NSW RURAL FIRE SERVICE

Your Ref: SSD 7198
Our Ref: DA-2019-01301

6 August 2020

Moonee Beach Residential Subdivision (SSD 7198) – Lot 1 DP 1097743, Pacific Highway, Moonee Beach

Scale Horizontal 1:500 Vertical 1:100

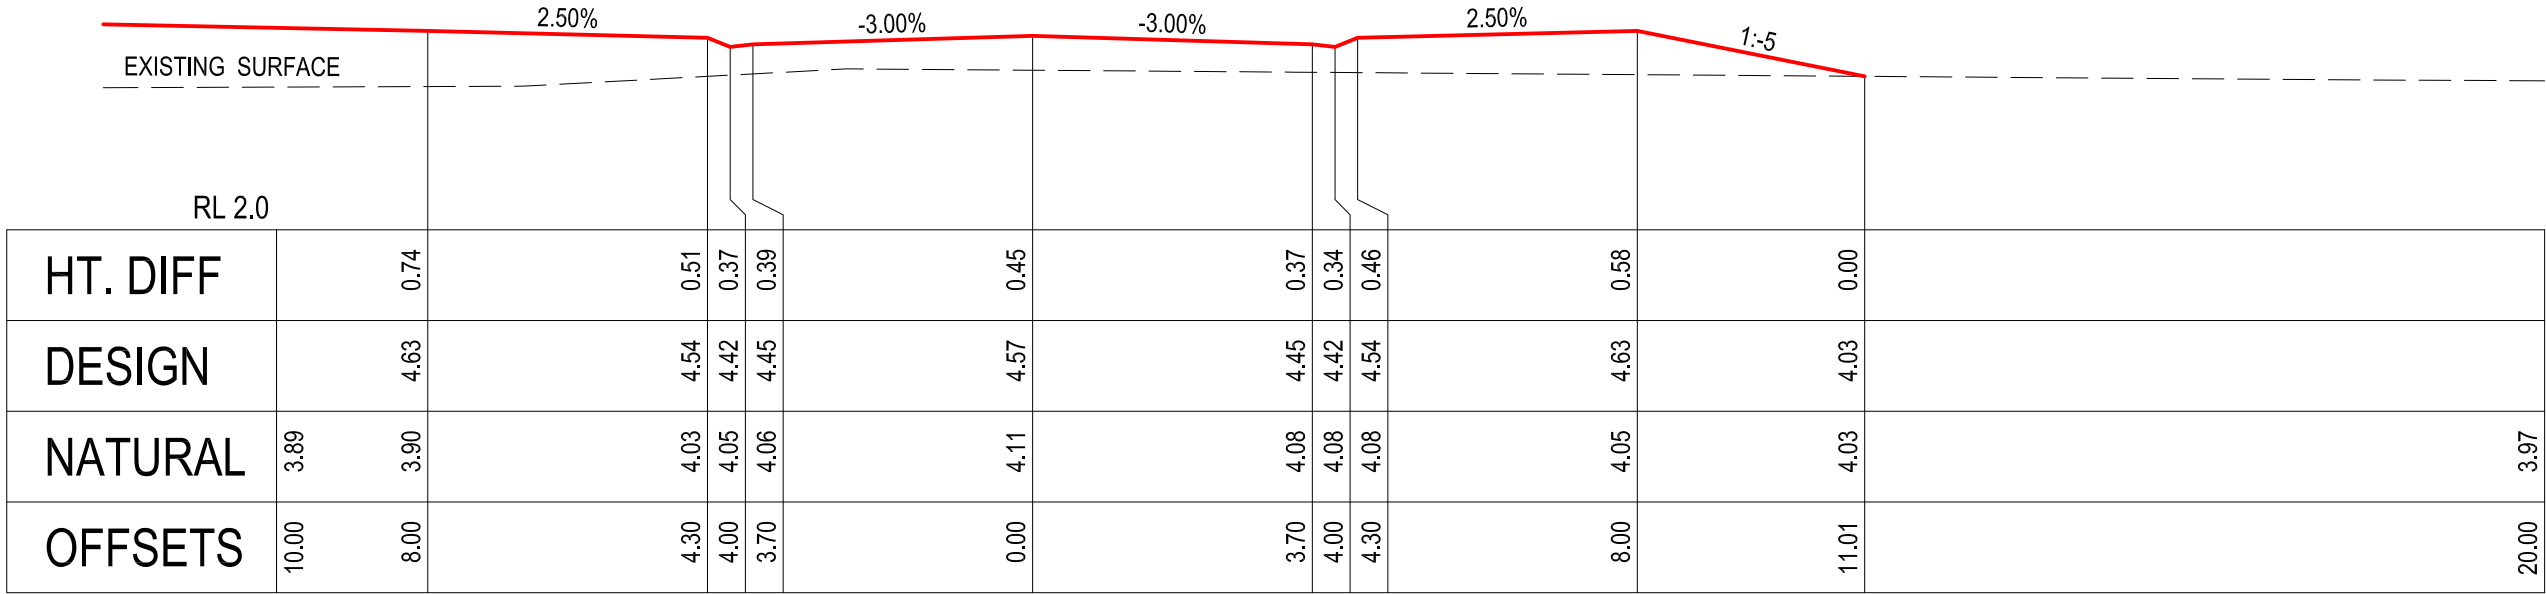
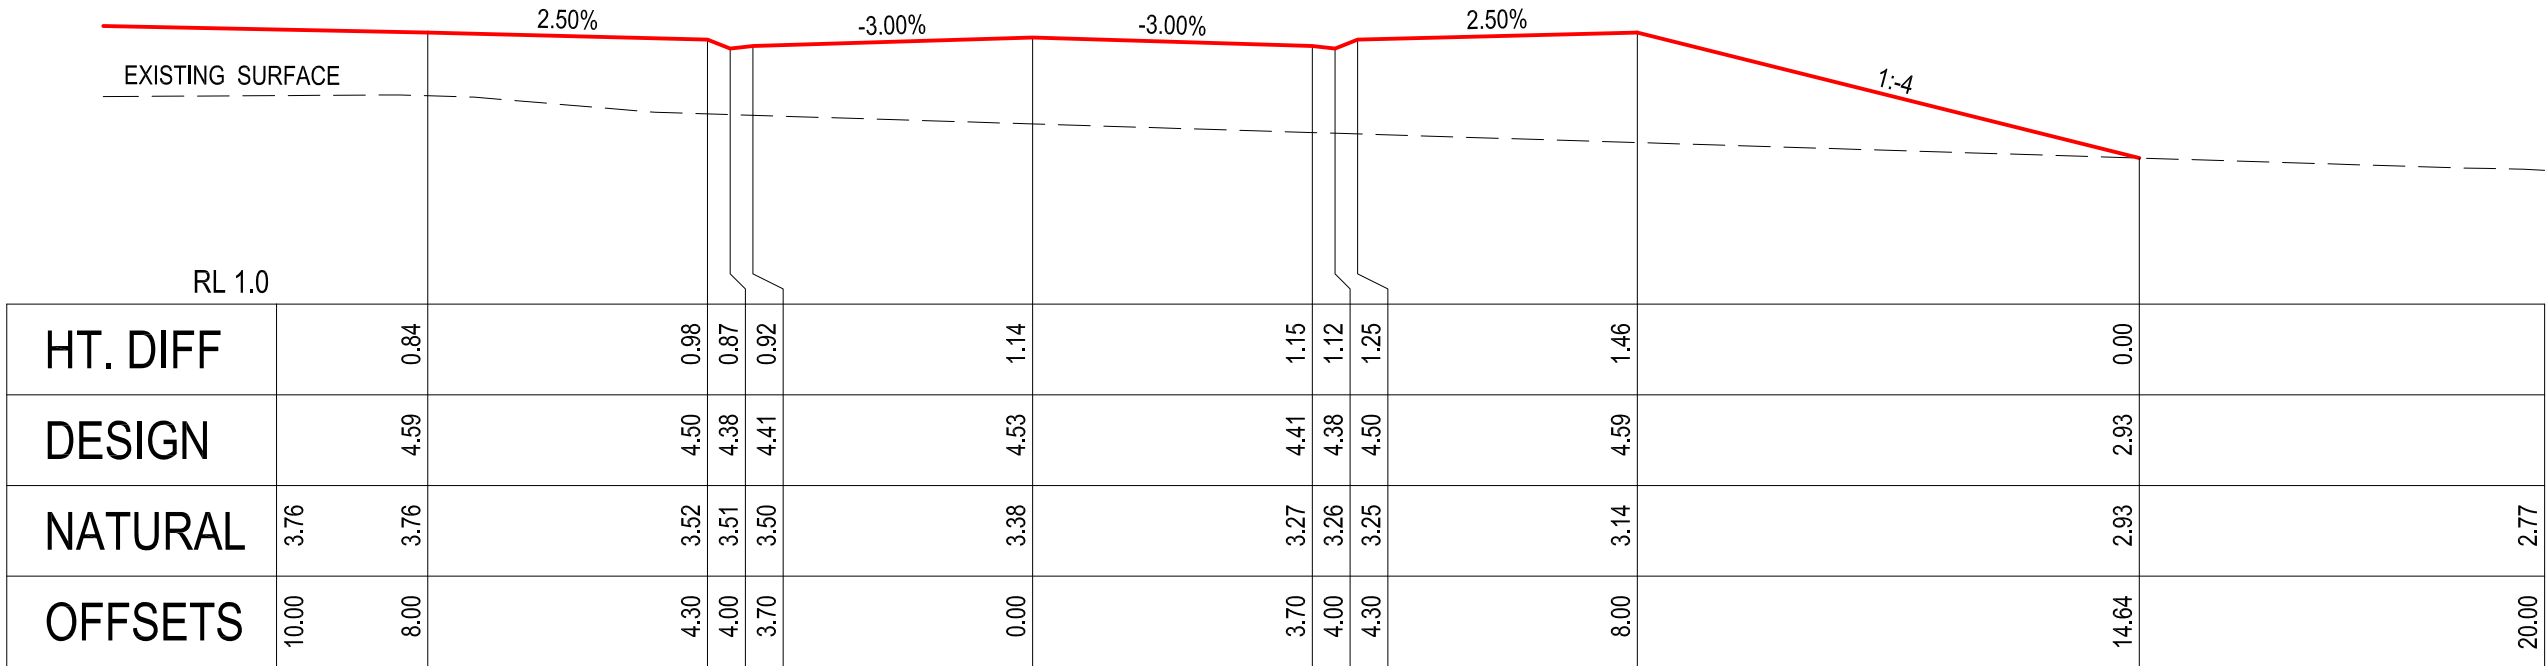
The NSW RFS also notes that the amended subdivision layout includes a new Road 7, providing access to the adjoining land to the south. No objection is made to this amendment.

8. Public road access shall comply with section 4.1.3 (1) of 'Planning for Bush Fire Protection 2006'.
9. Any temporary cul-de-sac created in the respective stages of the development shall provide an all-weather 12 metre outer radius turning circle.
